Addendum No. 1

RE: Contract # C204720

Pender County (I-6040)

I-40 FROM WEST OF US-117 (MM-388) TO NC-210 (MM-408)

# Pender County Maps 1-2

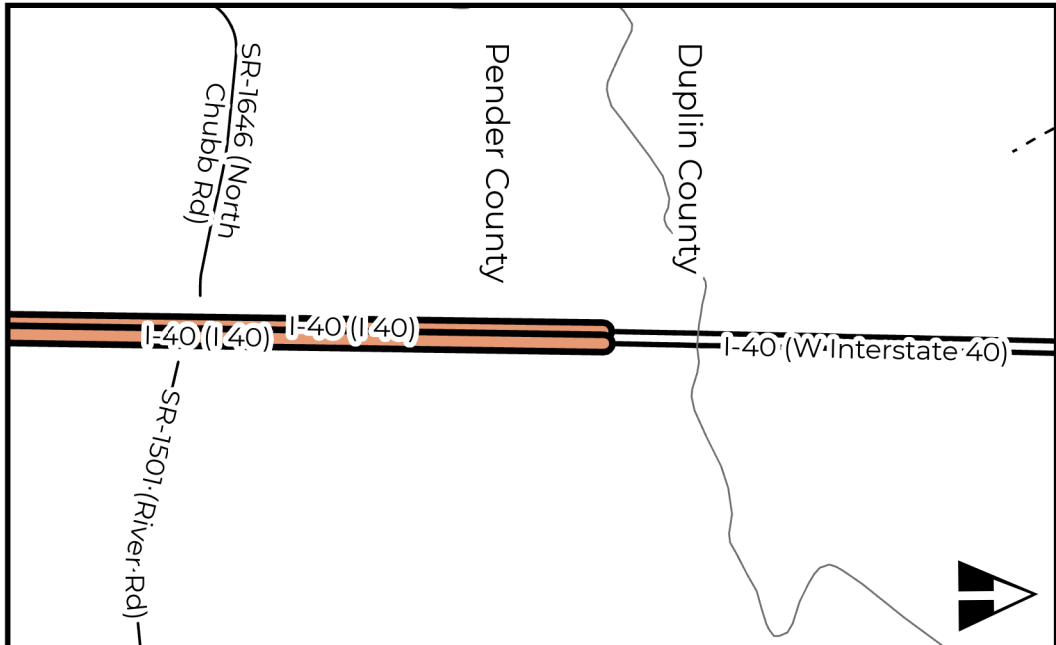
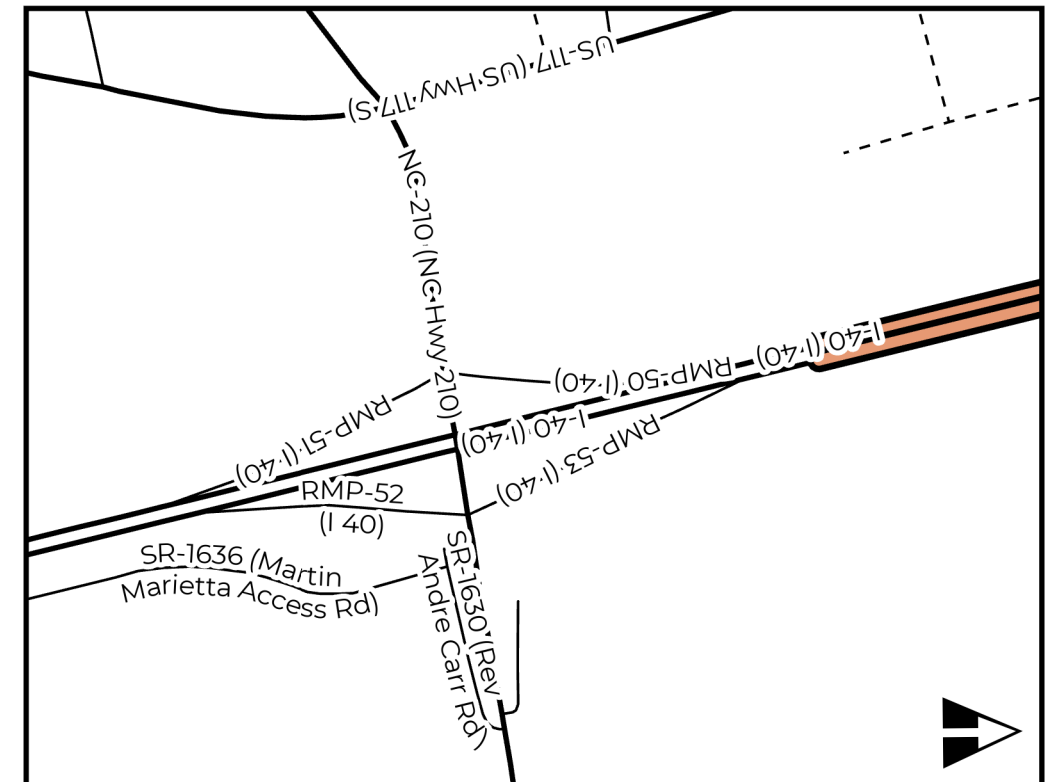
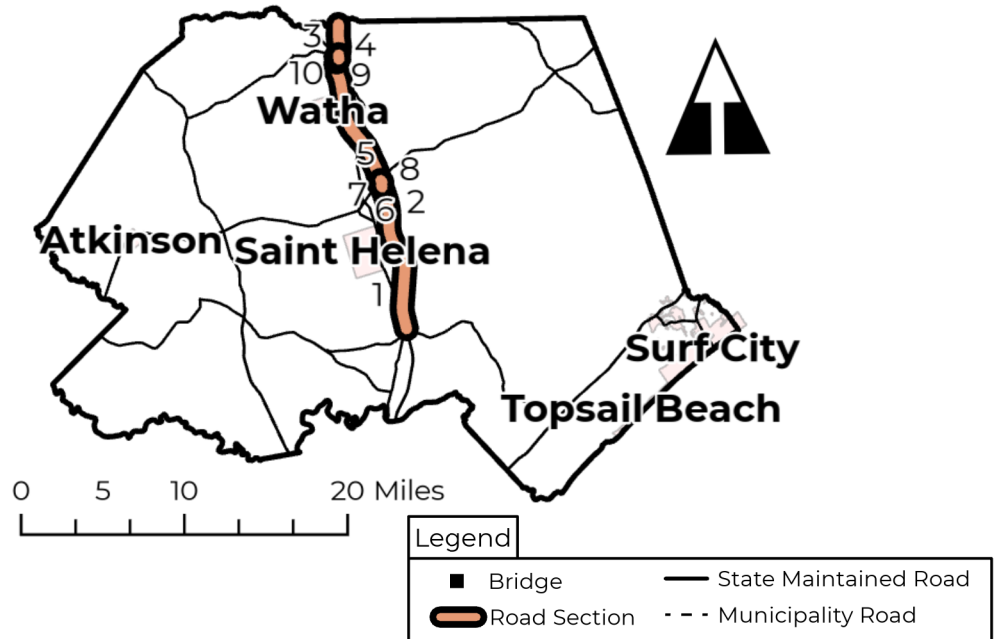
Page No.	Revision
Proposal Cover	Note added that reads "Includes Addendum No. 1 Dated 06-03-2022".
G-2	The Project Special Provision INTERMEDIATE CONTRACT TIME NUMBER 2 AND LIQUIDATED DAMAGES has been revised.

The Contractor shall complete the required work of installing, maintaining, and removing the traffic control devices for lane closures and restoring traffic to the existing traffic pattern. The Contractor shall not close or narrow a lane of traffic on **the following Maps** during the following time restrictions:

DAY AND TIME RESTRICTIONS**MAP #1 (EBL)****Monday thru Thursday, 6:00 AM to 8:00 AM****Friday thru Sunday, No Work Allowed****MAP #2 (WBL)****Monday thru Friday, 6:00 AM to 8:00 AM****Saturday & Sunday, No Work Allowed**
